# Rezoning Transportation Analysis

Petition Number: 2023-002

## Revision Log:

Date	Description
5-24-23	First Review (IW)

RZ-1

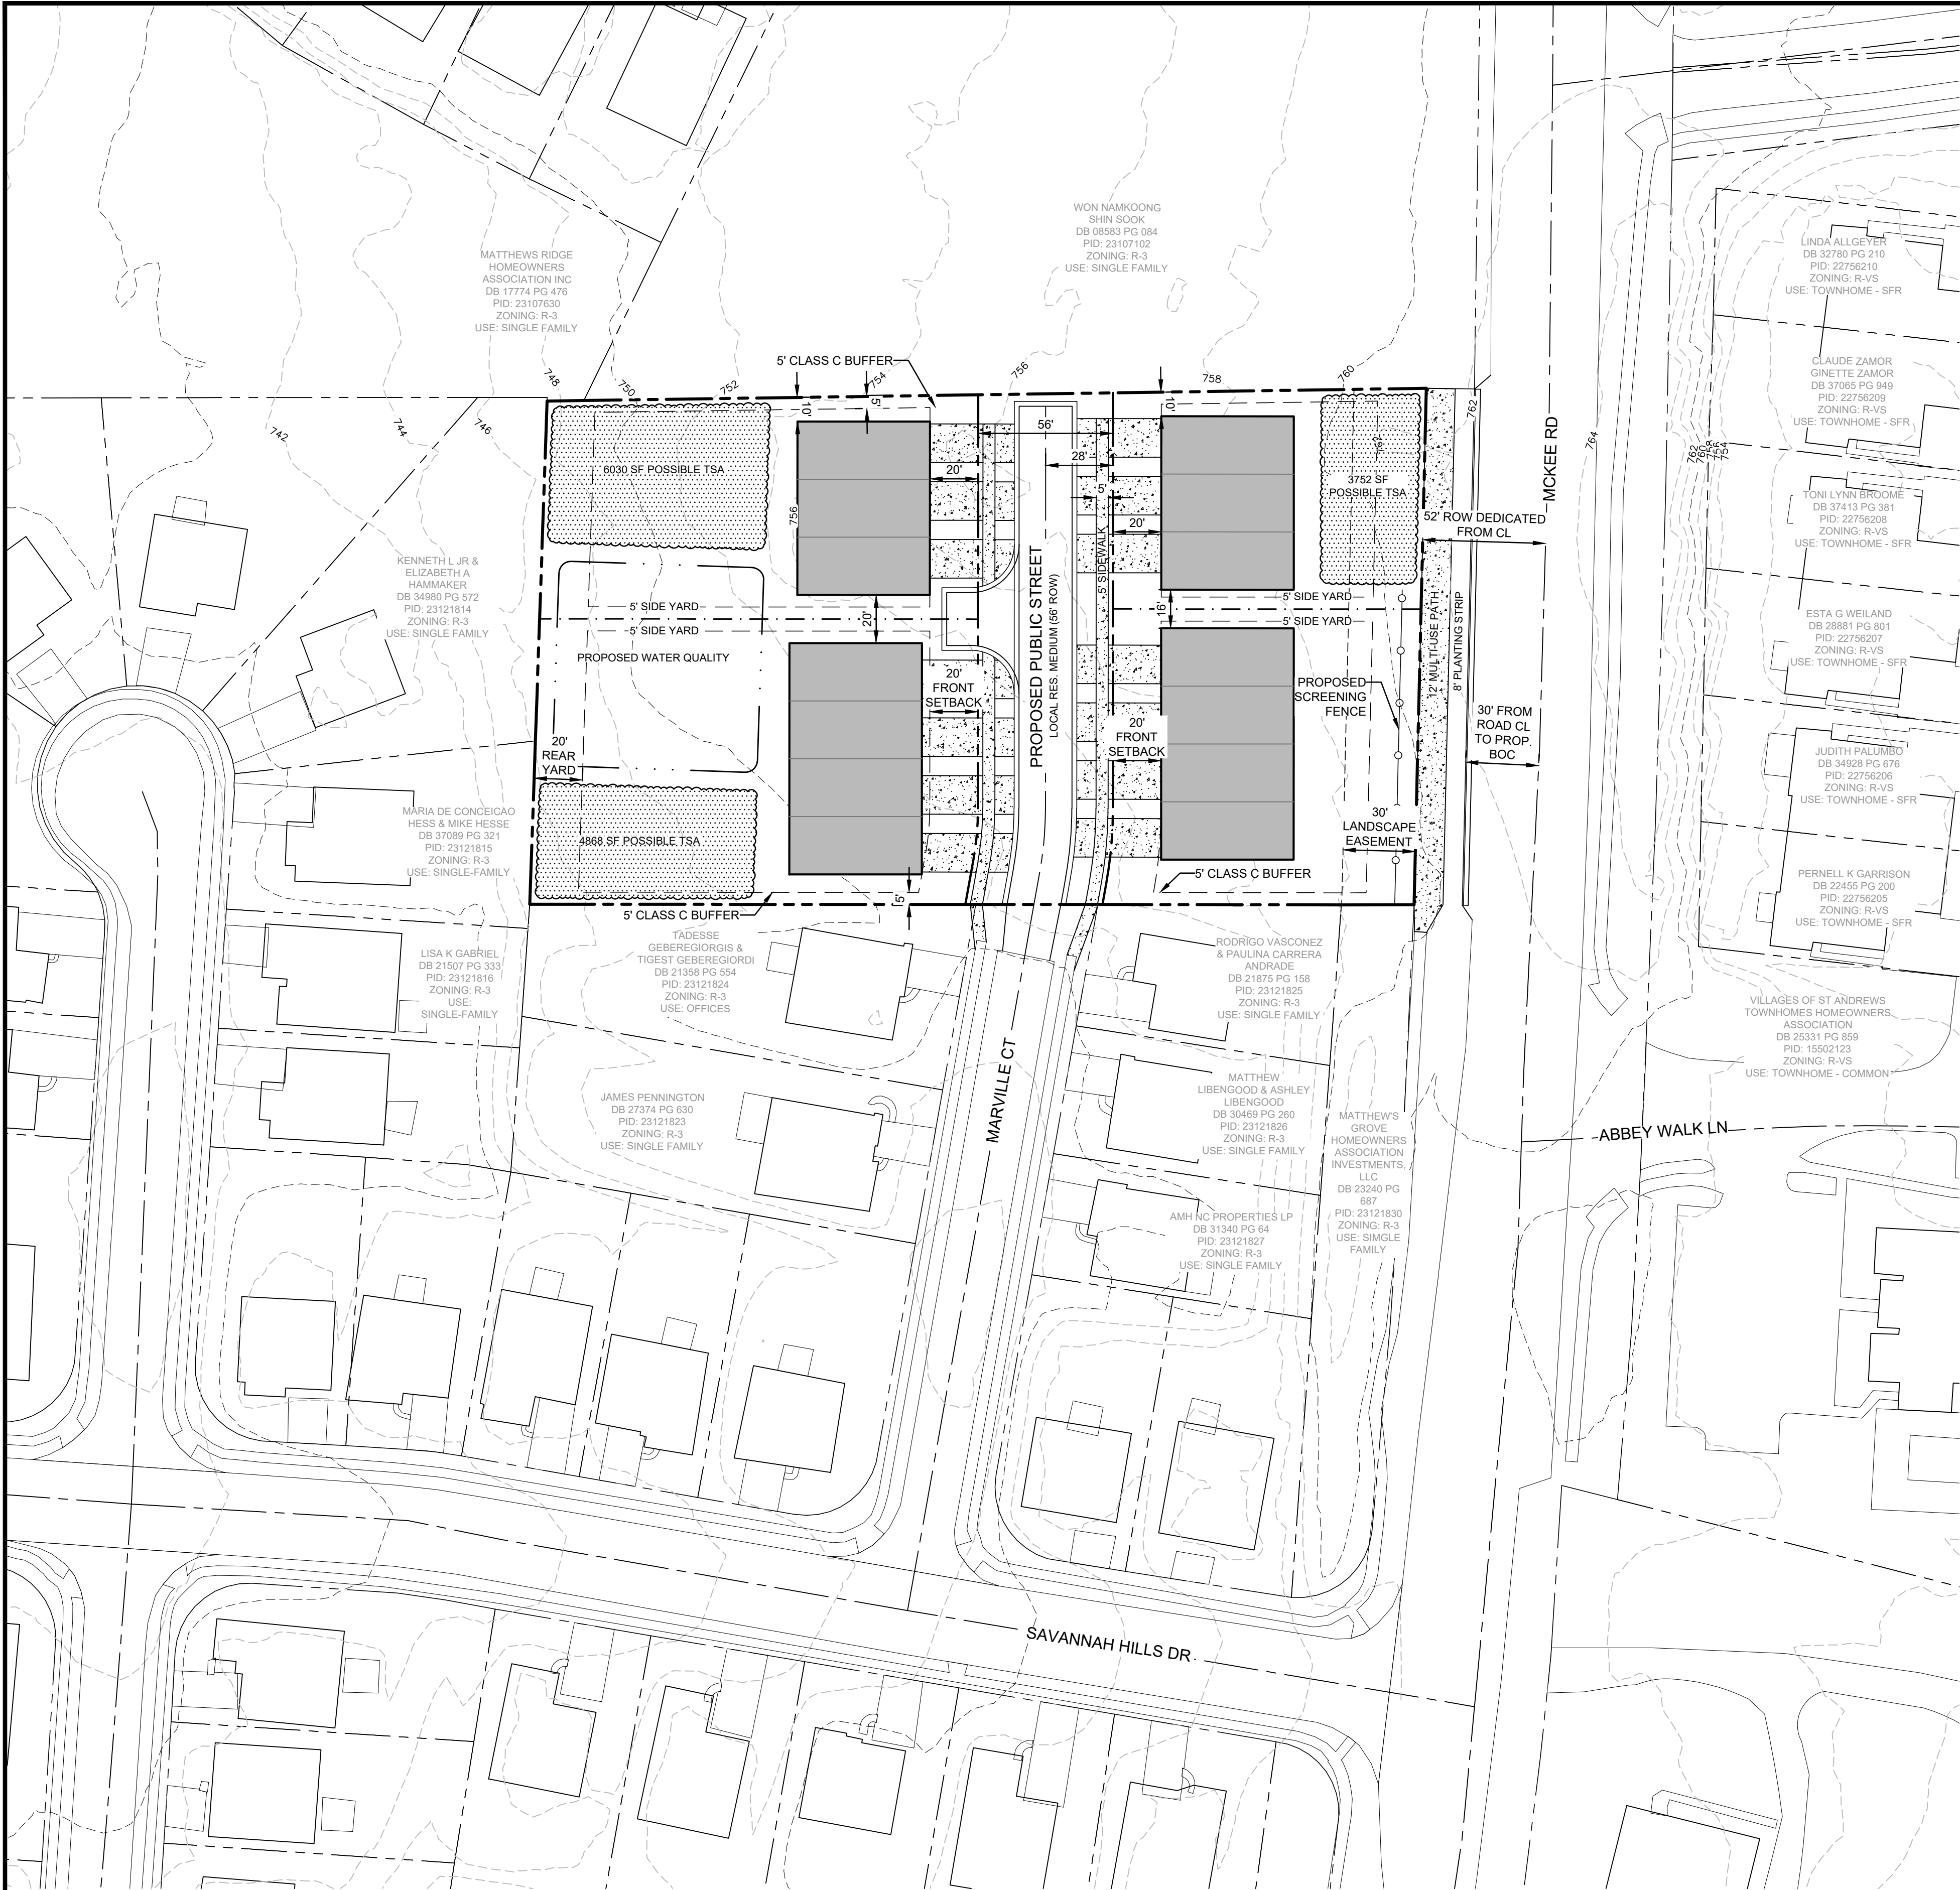
- a. **McKee Road:** Future location of curb and gutter to be 30 feet from roadway centerline to accommodate the Charlotte Streets Map with a roadway typical section of 4+ Avenue.

NOTE: Additional distance from center line to back of curb may be required in locations where a median is present or around intersections and interchanges.

Label and dimension the curb and gutter from the centerline for each road on the site plan.
